March 7, 2023

Kelly Bacon  
Planner 1  
Kittitas County Community Development Services  
411 North Ruby Street, Ste 2  
Ellensburg, WA 98926

Re: Letter of Concern regarding Conditional Use Application CU-23-00001

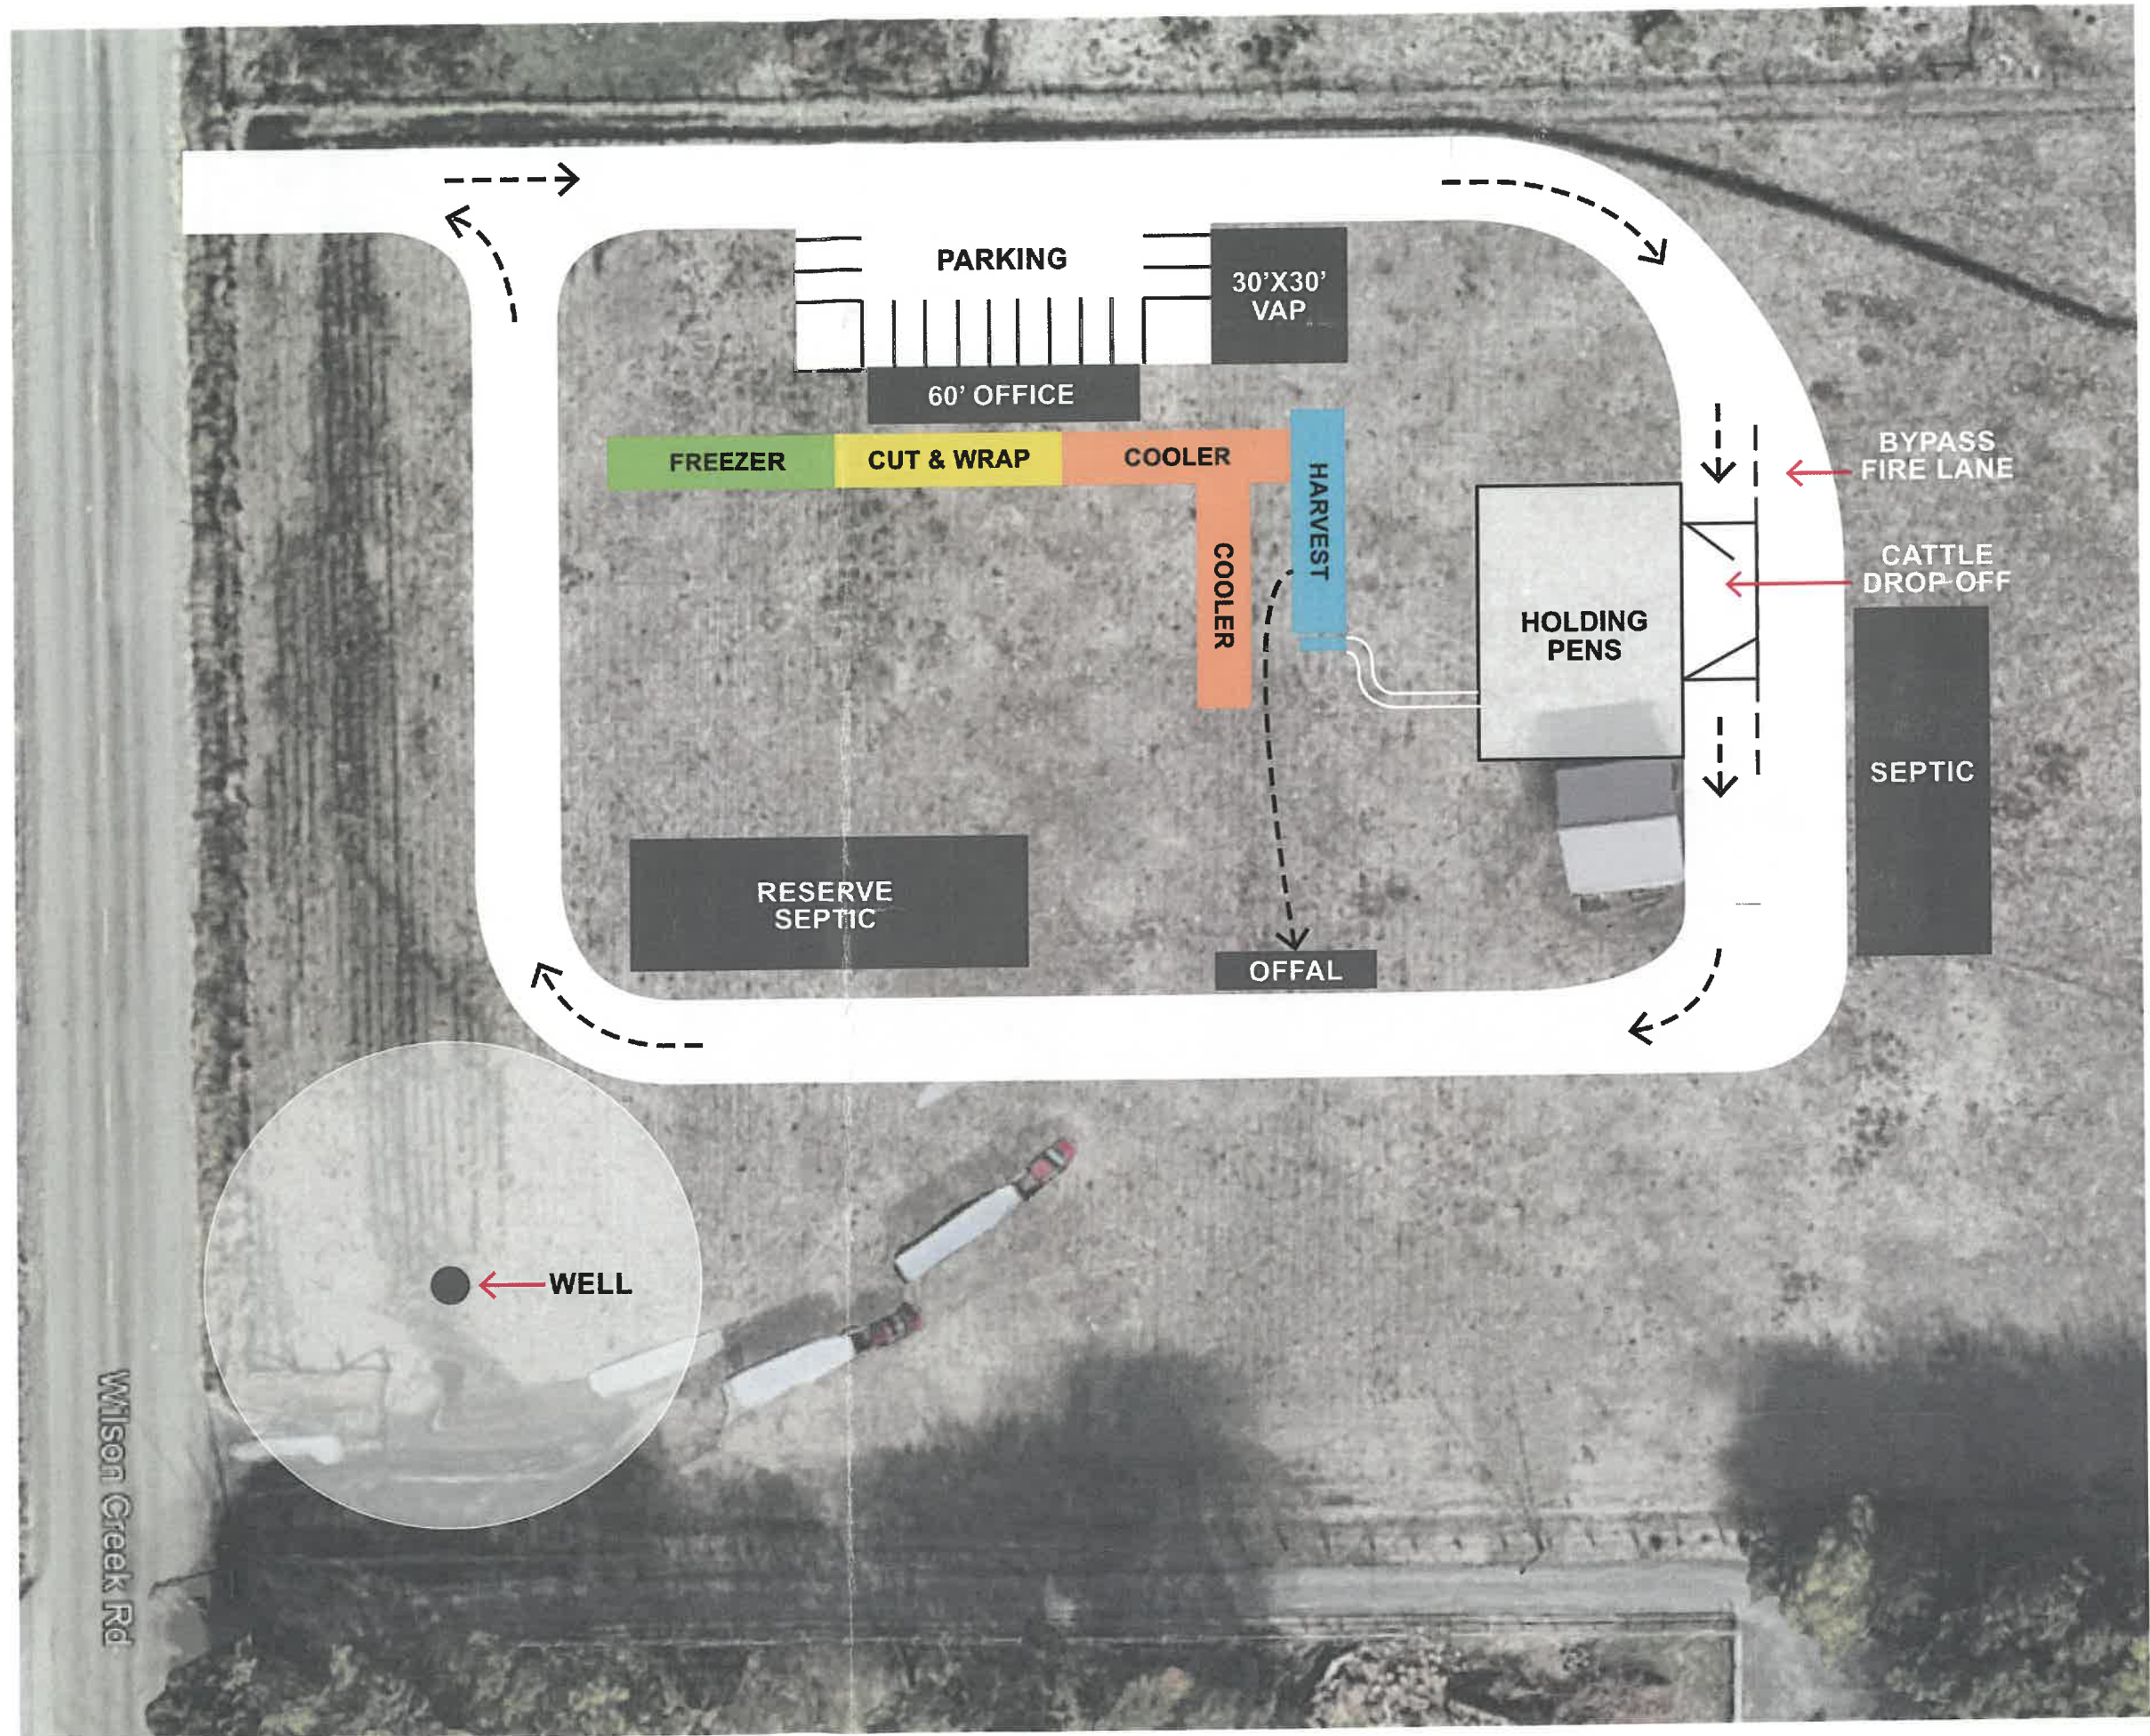
- Offal is denoted on the Site Plan. Offal is the "Meat, including internal organs (such as liver, heart, or kidney) and extremities (such as tail or hooves), that has been taken from a part other than skeletal muscles..."<sup>4</sup> We are concerned that the offal also poses a potential public health concern. A cow with a live weight of 1,000 pounds yields a 630<sup>5</sup> pounds carcass—leaving 370 pounds of offal per cow—10,917 cows could potentially produce 4,039,290 of offal per year. There is nothing in the application that describes how this offal will be contained. We question whether it can be contained in a manner where the scent does not attract predators, vermin, and insects.

*We are confused by this statement that 98% of the location will remain in AG—the area covered by the processing facility encompasses approximately 95,9720 (extrapolated from the Site Plan) this is about 14% of the 14.90 parcel. Categorized in the Manufacturing Sector by NAICS meat processing would be considered is considered Industrial use. The meat*

*processing facility is planned for the front of the parcel which is the most populated and quite near the adjacent parcels to the north and south. This proposal is not compatible with the A-5 Agricultural Zone. This is a long narrow parcel, the narrow portion on Wilson Creek. The trees which are noted in the Belsaas & Smith Project Narrative are totally inadequate to mitigate this incompatibility and limit in any way the disruption to the neighborhood...most particularly to the adjacent properties.*
